**From:** alan.story@hertfordshire.gov.uk  
**Sent:** 22 September 2014 13:29  
**To:** Planning  
**Subject:** Planning application N6/2014/1862/AD - 31 Stonehills

**District ref:** N6/2014/1862/AD

31 Stonehills  
Welwyn Garden City  
AL8

Installation of one fascia aluminium box frame, aluminium fascia panel with fret cut acrylic lettering with vinyl applied

DRAWING TITLE: ELEVATIONS - PRO VS. EXT
DRAWING NUMBER: SV-WEI/WH-1.3 DWG
SCALE: AS SHOWN
PROJECT: 31 Stonehills, Wilwyn Garden City, AL8 6JA

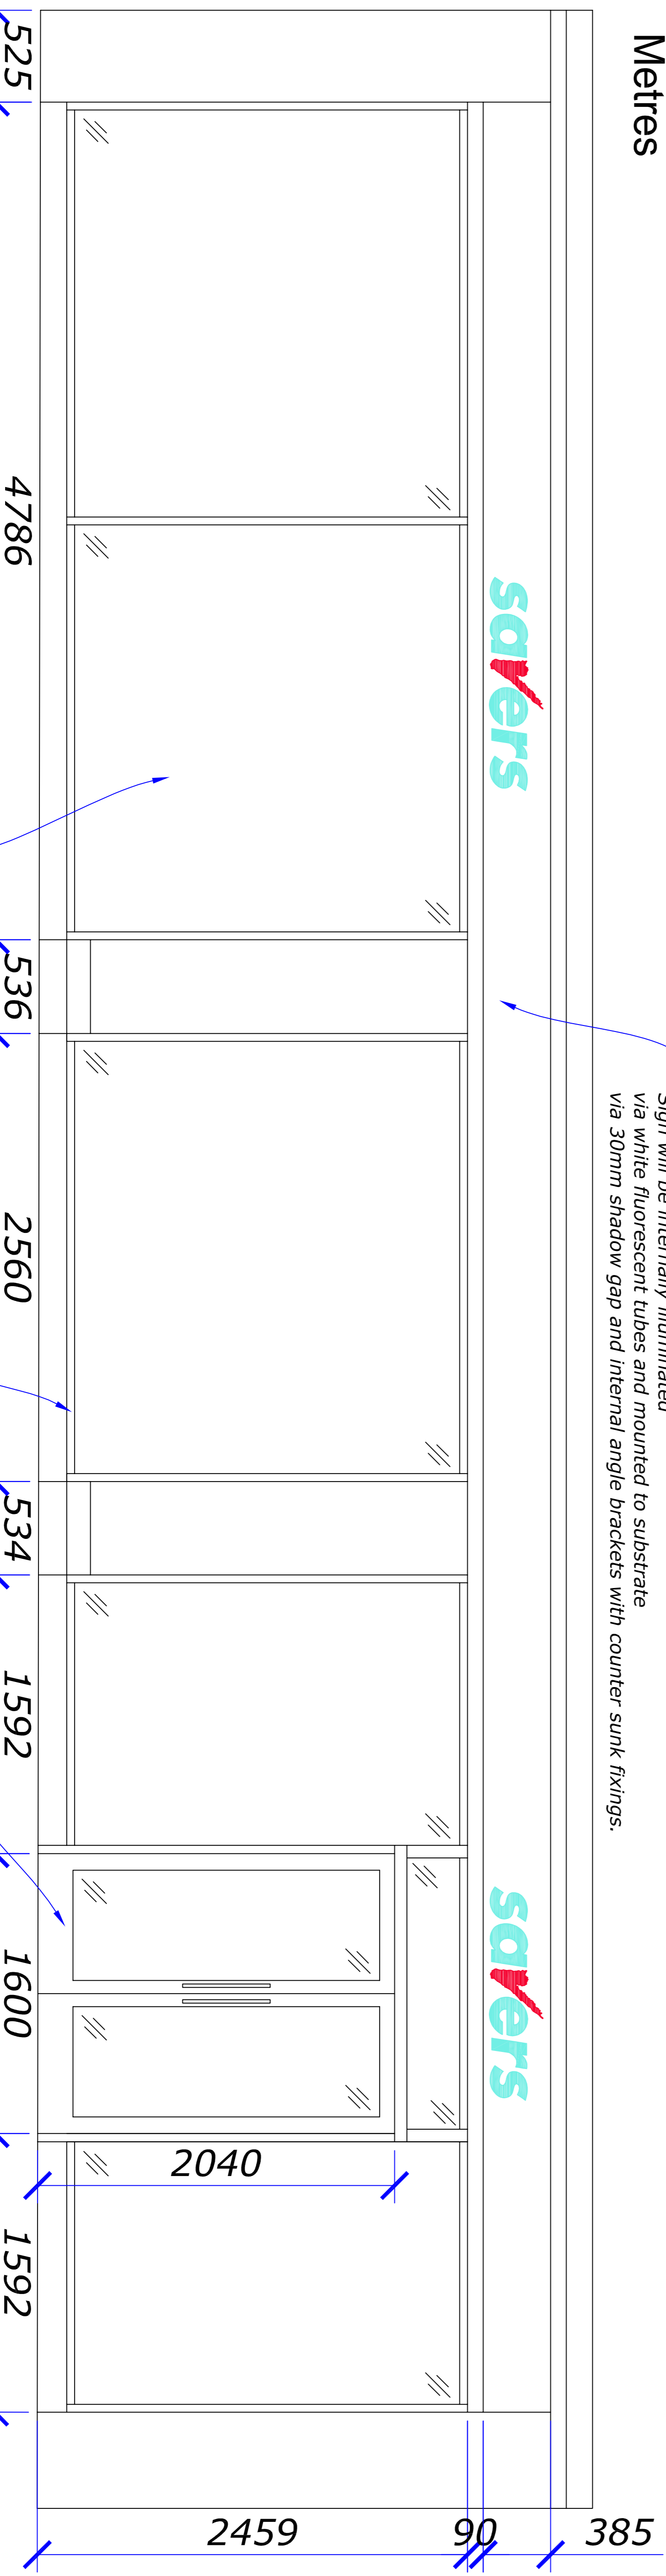
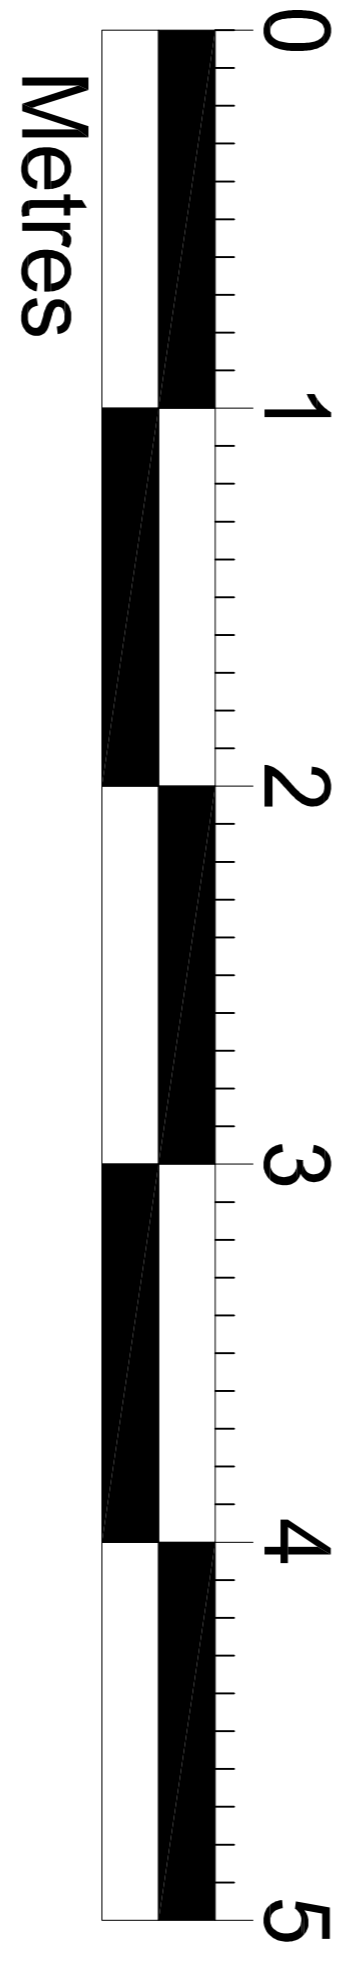
It is observed that the information available is restricted to drawing SV-WELWYN-L3-DWG, but no application form. The drawing suggests proposed signage is internally illuminated, but there are no levels of illuminance (Cd/m<sup>2</sup>) specified. The above condition is therefore necessary to control the affect of the illumination on the adjacent network.

1 The intensity of illumination shall be controlled at a level that is within the limit recommended by the Institution of Lighting Engineers in the publication "Brightness of illuminated Advertisements" ILE Technical Report No 5, and shall be non-intermittant in nature. Reason: So that drivers of vehicles along the adjacent highway are not dazzled or distracted, leading to interference to the free and safe flow of traffic along the highway.
